**Applicant:** Harper Crewe Bloombridge Ltd

**Proposal:** Outline planning application with All Matters Reserved (except means of access) for up to 340 dwellings (Use Class C3), land for local community use and pavilion, landscaping, public open space, and associated infrastructure, including demolition of 162 The Moors to enable all modes of access

**SUMMARY RECOMMENDATION: GRANT PERMISSION SUBJECT TO CONDITIONS AND SUBJECT TO A S106 LEGAL AGREEMENT.**

Proposed Site Access Raised Table Roundabout

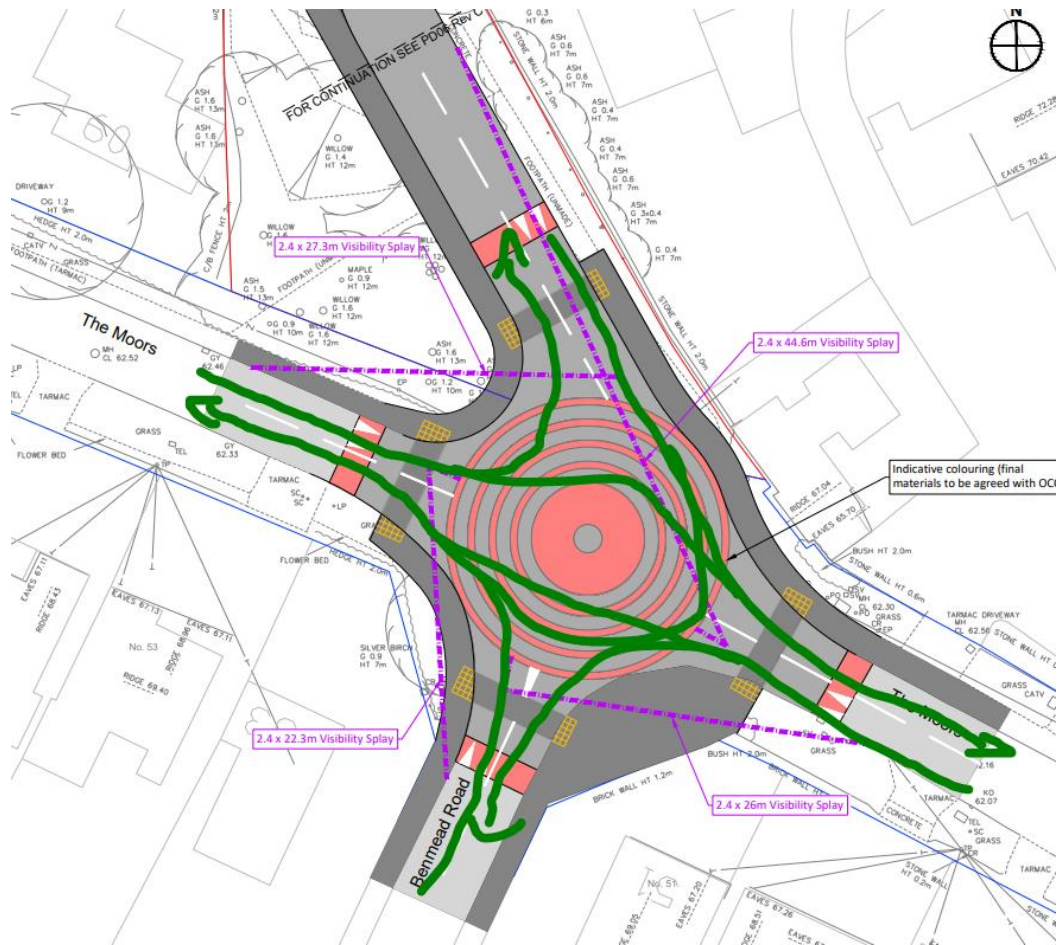
- A site access raised table roundabout is also proposed. However, a swept path analysis of refuse vehicles manoeuvring around the roundabout is required. Confirmation is also requested on whether the proposed roundabout is a mini or compact one, informed by the average daily traffic flow, which needs confirmation. Further details regarding visibility splays, surfacing, gradient and markings for the roundabout were also requested.

6. Land Use Parameter Update

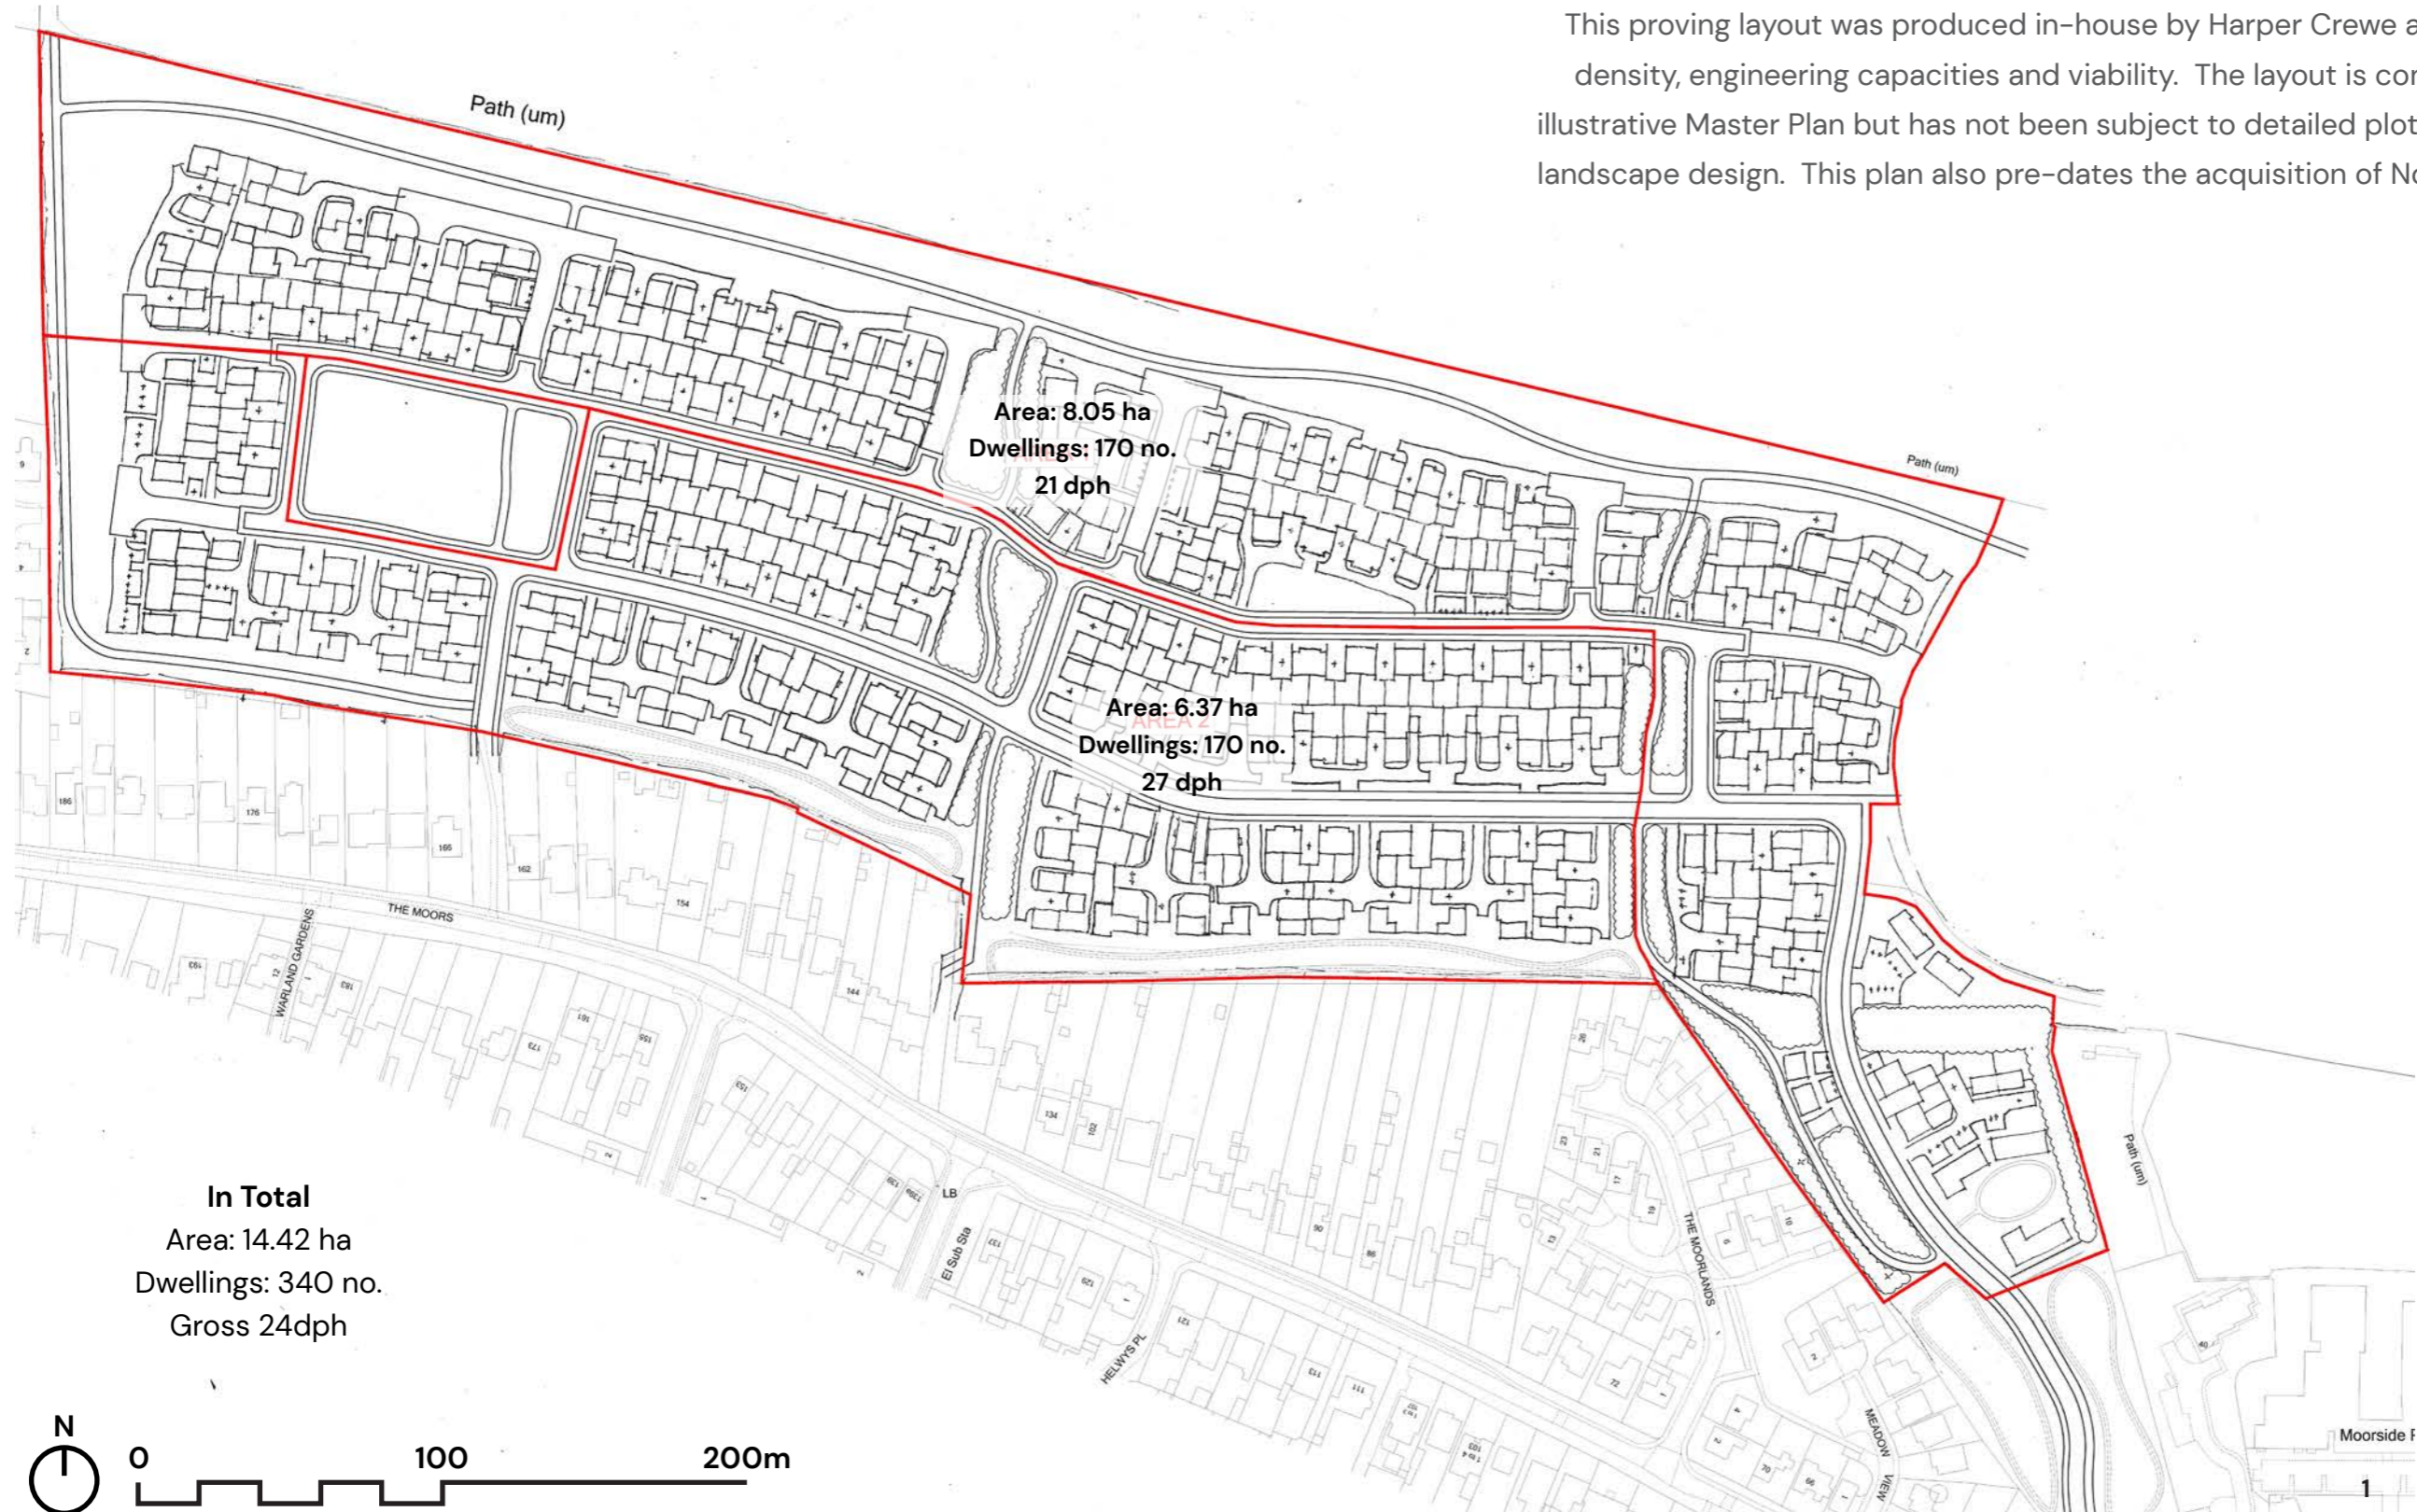
- Parameter Plan: Please remove the word 'circa' in relation to the Western Green.
- Additional Information: Based upon the illustrative masterplan, please provide a clear indication of the densities proposed across the site and vignettes at key locations to demonstrate the approach to density/parking/ street scene to demonstrate the scheme can be delivered in accordance with policy, guidance, and best practice.

7.21. The applicant provided further information, and a response note to the latest comments by the Urban Design Officer. The parameters plan removed the word circa in relation to the Western Green. However, the requested information on densities was not provided.
